Date: 06-Nov-2025
Our Ref: 2025/92333

**Discharge of details reserved by conditions 3 (materials), 4 (boundary treatment), 5 (floor levels), 8 (bins), 9 (footway), 11 (CEMP), 12 (Tree Protection) and 13 (landscaping) on previous permission 2024/91852 for erection of 3 detached dwellings and detached gym associated with one dwelling, with associated highways, landscaping and external works
30, Lightridge Road, Fixby, Huddersfield, HD2 2HF
Application Number: 2025/92333**

PROPOSED SITE PLAN.
1:200

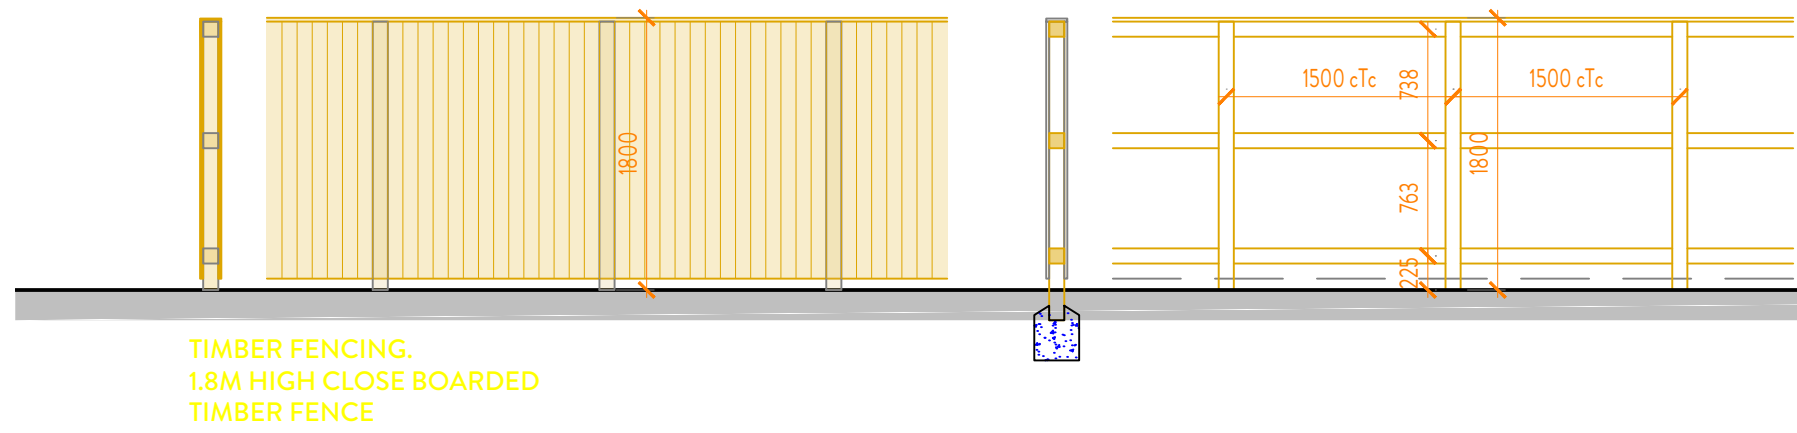
Drawing No's 24014/S278/001 to 24014/S278/008 inclusive and (20)001 Rev C has been submitted by the applicant. However, the applicant has not contacted the Highways Design and S278 team to discuss the proposals and has not received technical approval.

There are a few issues that will need to be addressed regarding the proposals, and the applicant is requested to contact the Council's Highway Design and Section 278 team to progress this through the Section 278 process to receive technical approval.
